**KIRKLEES METROPOLITAN COUNCIL
INVESTMENT & REGENERATION SERVICE**

DELEGATED DECISION TO DETERMINE PLANNING APPLICATIONS

Reference No:	2024/62/90932/W
Site Address:	Land Adj, 4, Downing Street, Linthwaite, Huddersfield, HD7 5PU
Description:	Erection of detached dwelling
Recommending Officer:	Tom Hunt

Officer Report

Street Scene Elevation SE
1 : 100

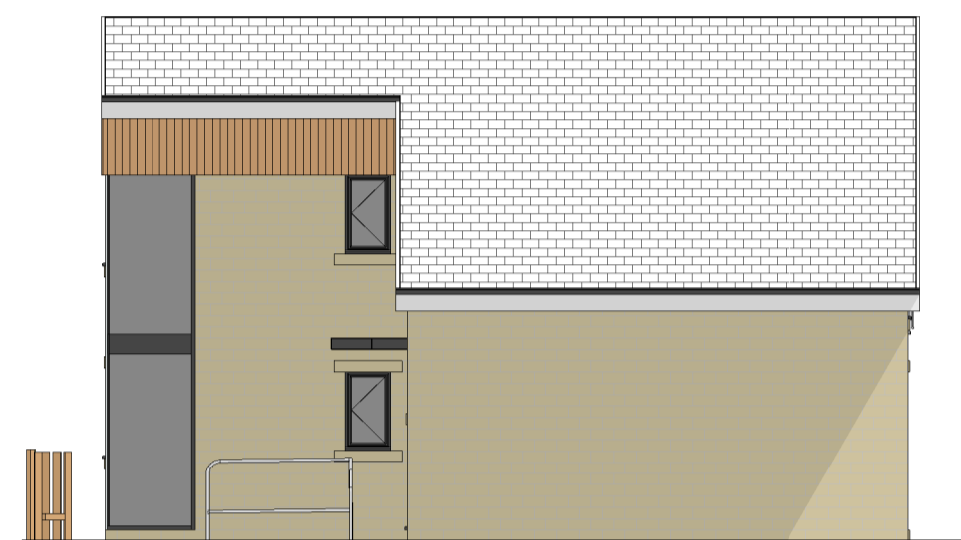
Officers consider the proposed dwellinghouse would appear cramped and contrived in between a pair of two-storey houses benefiting from a sense of spacious openness in their property gaps to flank boundaries. It would not fulfil Council requirements to have a two-storey dwellinghouse with 2m separation distance to flank boundaries. While it tries to mitigate this visually overbearing effect with a reduction in bulk and massing within its L-shaped plan form and reduced eaves to the east boundary, this would still appear

cramped and contrived within a small, narrow and tapering plot. Its narrow form would contrast with and appear incongruous with the existing wider examples of built detached development within the area. It follows that a smaller, narrower design with sufficient property gap to flank boundaries would appear even more contrived in between such large adjacent properties. In addition, it would remove views of the wider Green Belt/countryside setting and would harmfully reduce openness and erode the local character of the streetscene to a much tighter form of uncharacteristic dense development. The host would have its parking to the front and supported by a turning point with minimal soft landscaping leading to a visual dominance of vehicular clutter and harsh hardstanding. The streetscene has properties sufficiently set back with swathes of landscaping to soften the required driveways; developing the application site would appear to remove the pleasant landscaping of no. 4 to leave just the front as hard standing; should the previous permission 2018/91970 be revived or this garden plot be developed for a new dwelling, this would cumulatively appear car dominated and appear out of character with the original design of the cul-de-sac. The narrow width of the plot adjacent to the highway and the turning area limits opportunities to mitigate against this harm with greater areas of landscaping to aid in the scheme to appear in keeping with the locality. The proposal would retain sufficient garden space at rear to ensure that the scheme would appear to have a rear garden curtilage similar to its neighbours. However this would not overcome Officer's concerns regarding the cumulative effect of hardstanding to the front of no.4 and the proposed with an increasingly cramped and contrived appearance.

It is noted that the roofline would appear to follow the slope of the land and appear similar to neighbouring properties' rooflines to appear in keeping. It is noted that the architectural designs of the nearby properties could be considered varied in design and therefore the prominent cross gable roof or catslide design would not appear incongruous. In addition, it would reflect the existing material palette of its neighbours by use of natural stone and grey tile to ensure it would harmonise itself to the streetscene; the limited use of secondary materials in timber would be a minor deviation in the material palette however the locality does have variation in materials to allow this to appear in keeping.

Ground Floor Plan
1 : 100

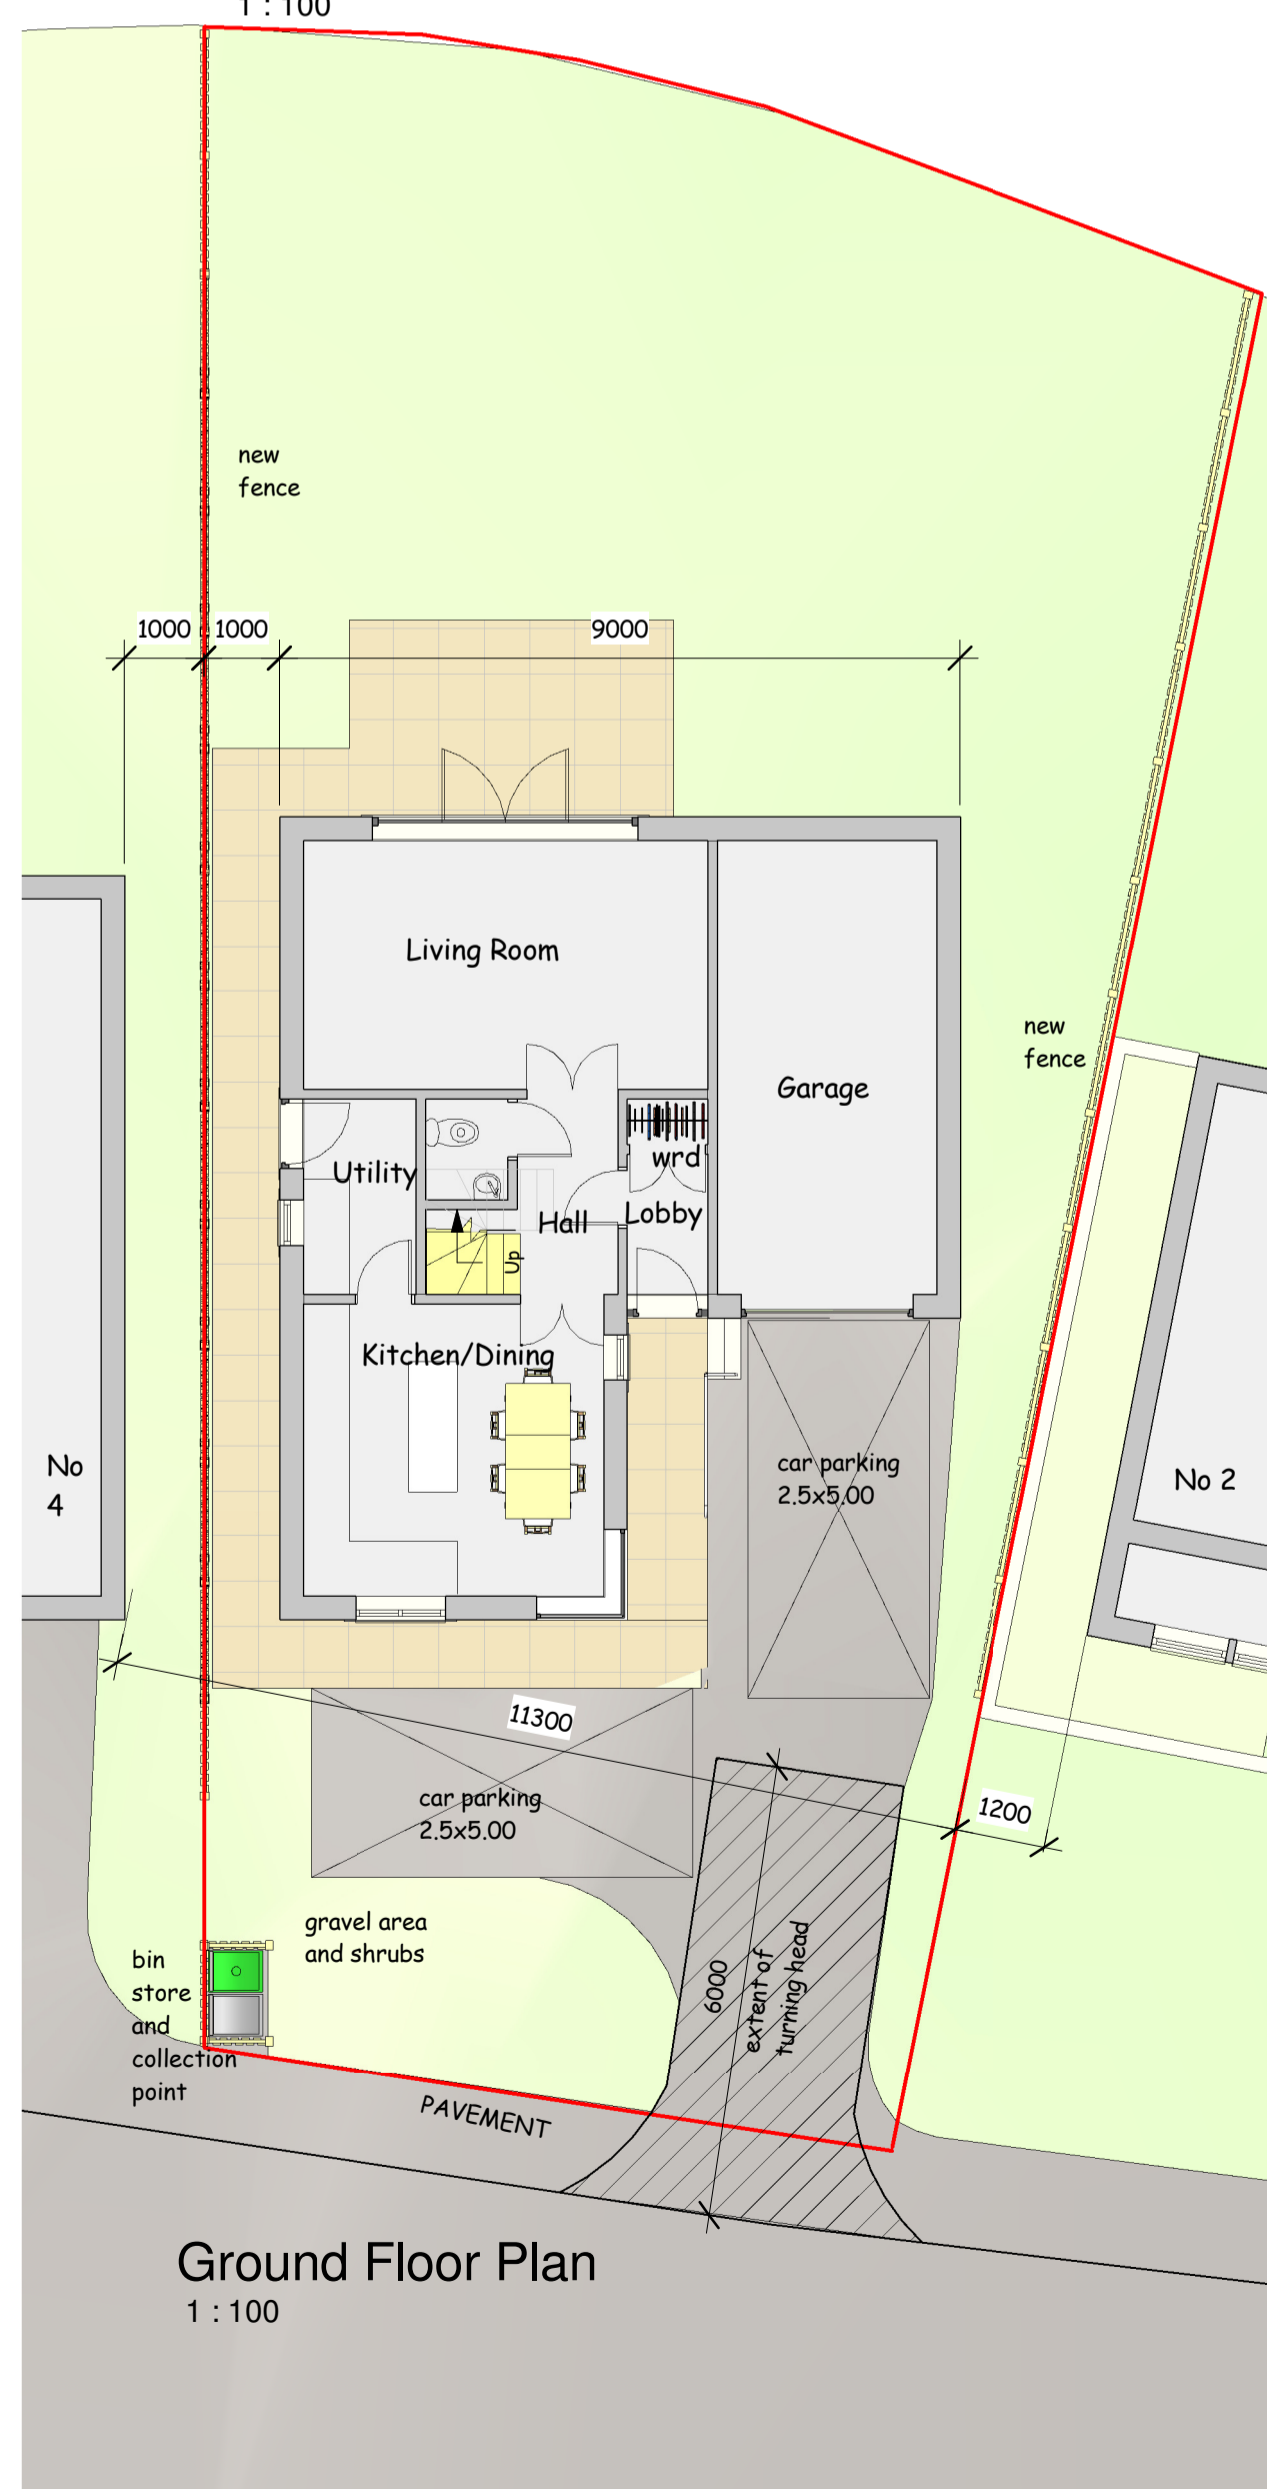
turning area in tarmac to the front leading to its integral garage. Two off street parking spaces are shown with minimum landscaping to front, and the garage's internal specification is 0.1m in width less than Highways Design Guide SPD recommended guidelines for modern vehicles. There would be a limited area of paving to the front, west side and rear.

Due to its asymmetric design, the greatest bulk and massing of the scheme would be to this neighbour. This would have a small window with glazed door, serving a utility room, to the ground floor and an ensuite first-floor window to the west side elevation. This would have a similar relationship to no. 4's facing openings on the side elevation albeit sited on modestly lower ground.

not changed since 2011). The windows would be separated by 2m between those elevations. In the absence of sections to show the relationship between those windows and the type of glazing to no.4, Officers are unable to fully conclude that the proposal would not have an additional overlooking or loss of privacy. A condition to have those proposed windows to be double glazed to level 5 and non-opening could be recommended to ensure this harm is suitably mitigated; however the proximity of the proposed bulk and massing with no adequate flank property gap would still add an unacceptable, visually overbearing and uncomfortable relationship between both neighbours, including future occupants, which cannot be satisfactorily overcome by condition. The bulk and massing of the proposed set northeast of no. 4 would have a limited impact regarding overshadowing to what is likely to be non-habitable rooms and could be acceptable.

Block Plan
1 : 500

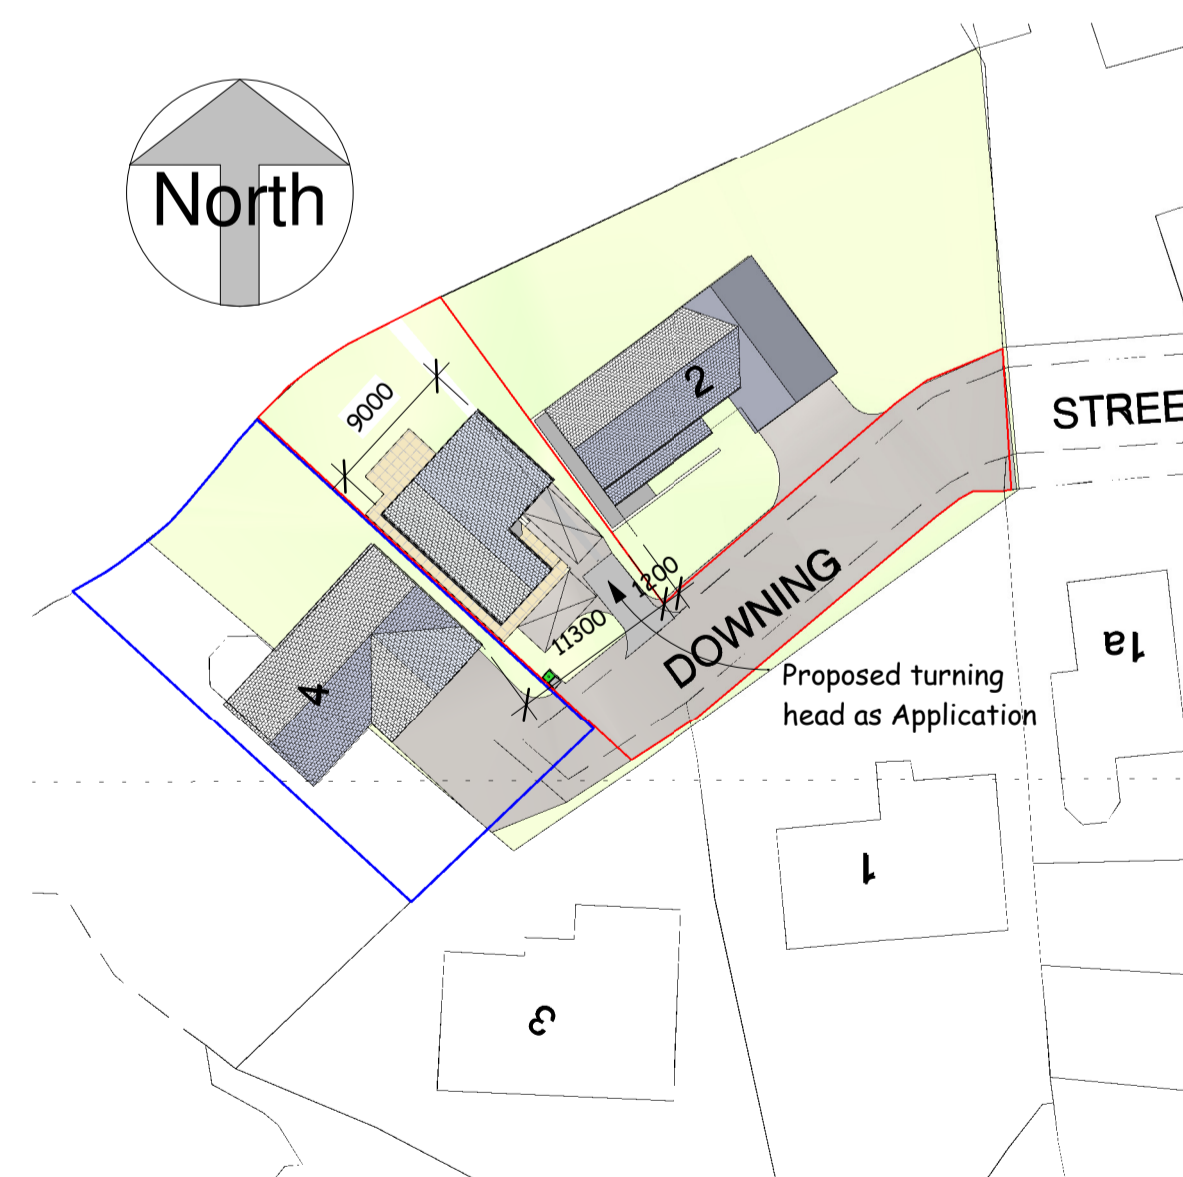
The proposal would be in line with the similar building line established by nos 2 and 4. This would be acceptable.

In conclusion, it is considered that the proposal by reason of its design, mass, appearance, proximity to site boundaries and overly dominant parking arrangement on a small plot would appear as an incongruous, cramped and contrived form of development within the streetscene which would cause visual harm and loss of spacious openness to the established character and appearance of the area.

Nonetheless, Officers concur that the proposed development to add one new dwelling to a private non-adopted highway which already supports five permitted, large dwellinghouses would lead to an unacceptable impact on highway safety, with severe residual cumulative impacts on the private road network in conflict with Policies LP21 and LP22 of the Kirklees Local Plan, paragraph 3.18 of the KC Highway Design Guide SPD and Chapter 9 of the National Planning Policy Framework. As previously indicated, the proposed car-dominated, parking layout with very limited landscaping would lead to a harmful visual impact in conflict with Principle 12 of the Housebuilders Design Guide SPD.

Fence Detail
1 : 20

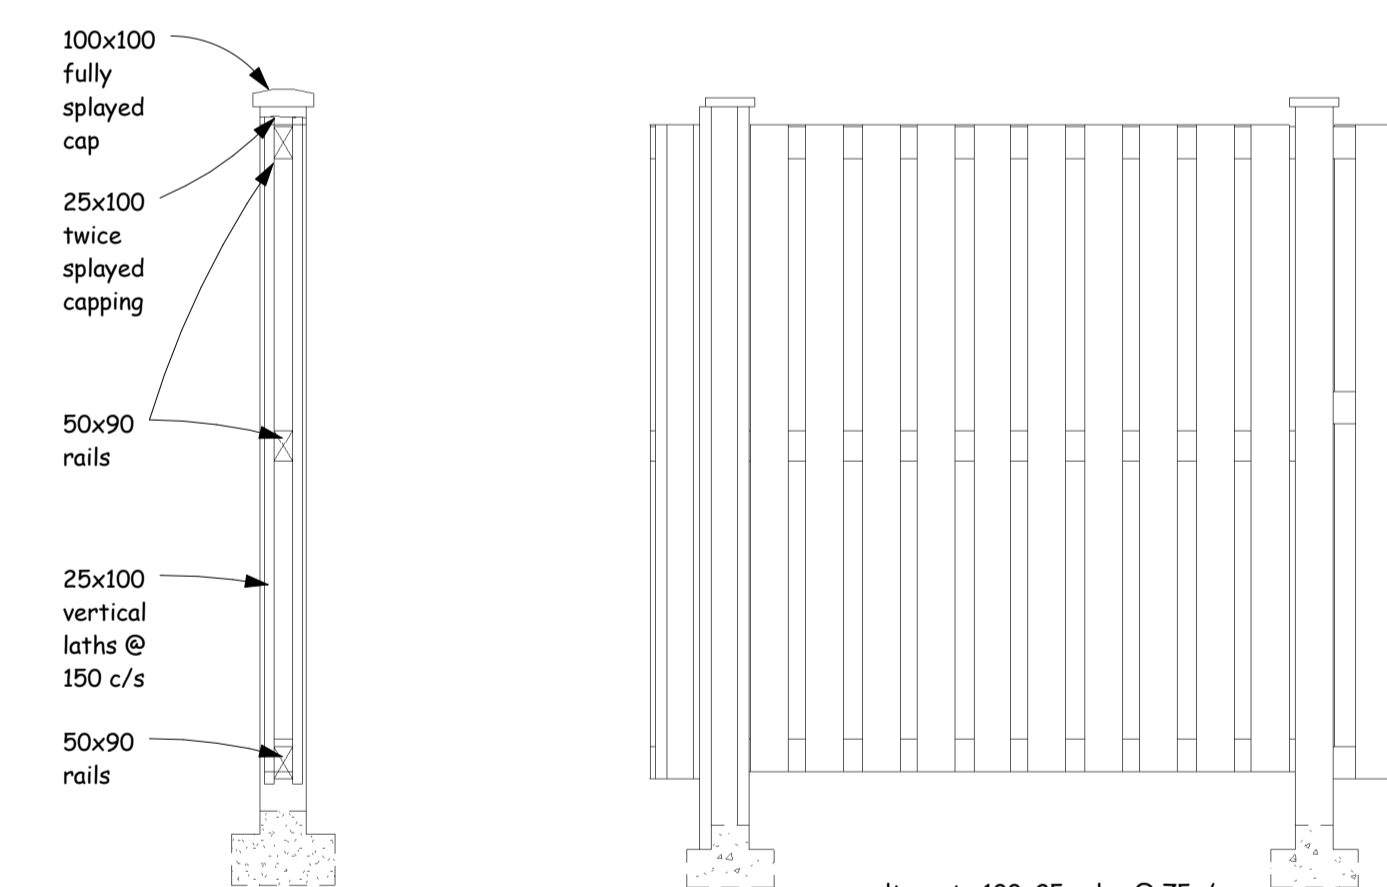
The dwelling would be faced in natural stone with infill timber boarding and roofed with concrete roof tiles. The boundary treatment would be a 1.8m height from ground close boarded timber fence. It would have a driveway with
